KIRKLEES METROPOLITAN COUNCIL INVESTMENT & REGENERATION SERVICE

DELEGATED DECISION TO DETERMINE PLANNING APPLICATIONS

Reference No:	2023/62/93468/E
Site Address:	14, Ladyroyd Drive, East Bierley, BD4 6RP
Description:	Demolition of existing garage and erection of replacement garage and two storey side extension with loft conversion
Recommending Officer:	Elenya Jackson

Project No : 2023_G123	Drawn by : AG
Date : 21/11/21	Drawing No: PL-008
Scale : 1:100@A3

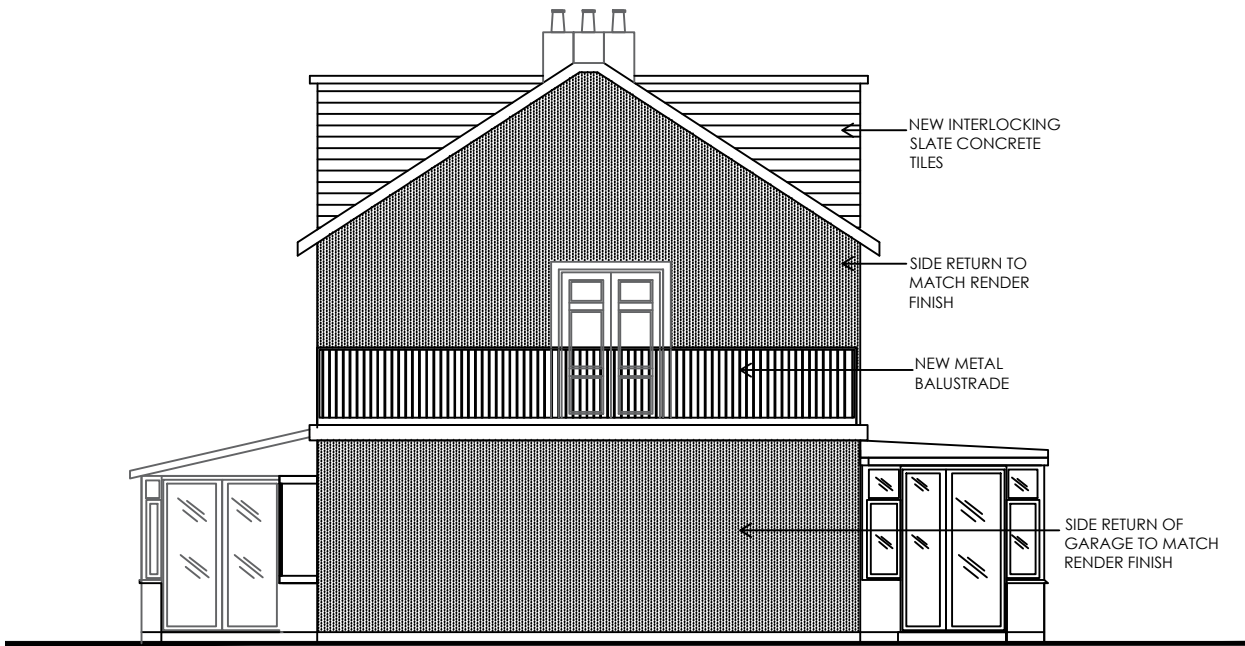
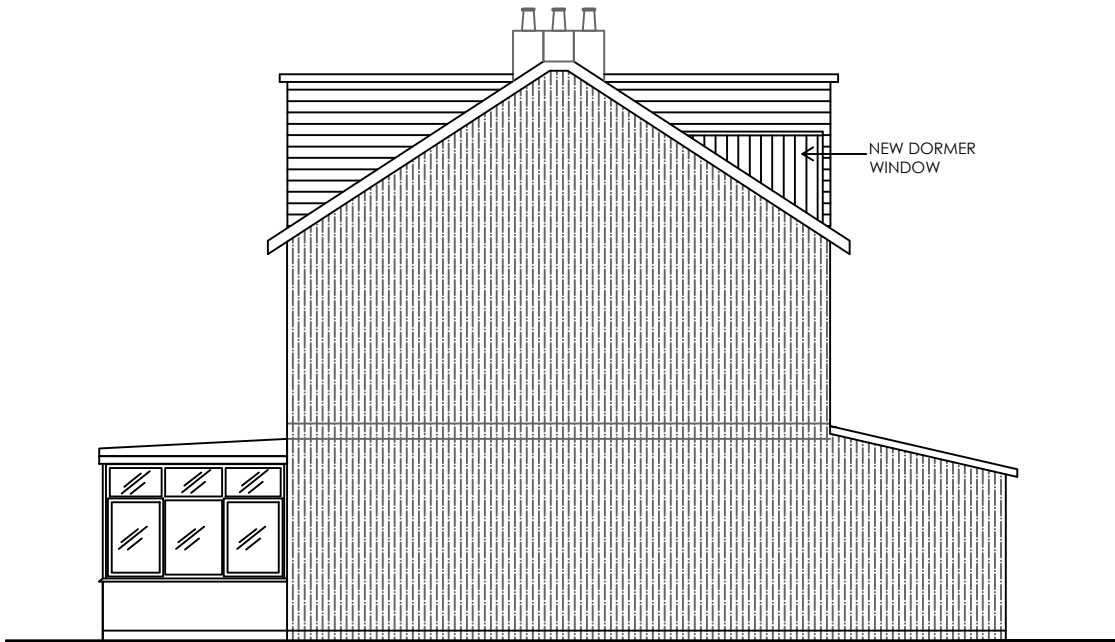
A two storey side extension which would not be set down or back from the host dwelling and would feature a gable end which would extend from the eaves of the dwelling, this design would be replicated to the rear. The dimensions of the two storey extension would be 3.8m in width, 7.2m in depth and would be flush with the front and rear of the dwelling. This would have an eaves height of 5.5m with a maximum height of 7.7m (matching the host dwelling).

A single storey side extension which would create a garage, this would have a width of 3m and a depth of 7.2m. This would have a maximum height of 2.9m with a boundary treatment at first floor level to provide a balcony.

The existing dwelling has a width of 5.9m, and the single storey side extension when combined with the two storey extension would result in a significant increase in the width of the dwelling. The extensions are not set down or set back from the host dwelling and therefore would not appear to be subservient to the host dwelling.

The proposal would also introduce a gable end into the principal elevation of the dwelling which would require the alteration of the dwelling to feature a gable end on its western elevation opposed to a hipped roof.

The properties within the street scene do feature a variety of roof forms; however, the application property is a semi-detached pair and the alteration of the roof to a gable would appear out of character with the host property. When coupled with the gable end to the principal elevation, this would result in an incongruous and out of keeping feature within the street scene and unbalance a semi-detached pair. The proposed hip to gable enlargement is therefore not considered to be acceptable in terms of visual amenity.

As previously detailed, the scale and mass of the extensions and in turn the overall volume of the dwelling would be substantially increased, and the proposal would result in disproportionate additions over and above the size of the original building which would fail to appear as subordinate. It is therefore

Overlooking: The proposal would feature a balcony over the proposed garage which would allow views to the south west and north of the application site.

This would be 5.9m away from the shared boundary between the dwellings. It is considered that the balcony would have limited screening and introduce a first floor platform in closer proximity to the rear amenity space of 16 than the existing relationship. Therefore the proposal would give rise to an unacceptable overlooking relationship.

1. The proposed extensions and roof alteration by virtue of their scale, mass, design and location would not be subservient to the original dwelling, would detract from the character and appearance of the host dwelling and unbalance the appearance of the semi-detached pair. To permit the proposals would be contrary to Policy LP24 of the Kirklees Local Plan, Key Design Principles of the House Extensions and Alterations SPD and guidance contained within Chapters 12 of the National Planning Policy Framework.

2. The proposed balcony, be reason of its proximity to the private amenity space of 16 Ladyroyd Drive would create an unacceptable overlooking relationship to the occupiers of that property. To permit the proposal would be contrary to Policy LP24 of the Kirklees Local Plan, Key Design Principles of the House Extensions and Alterations SPD and guidance contained within Chapter 12 of the National Planning Policy Framework.
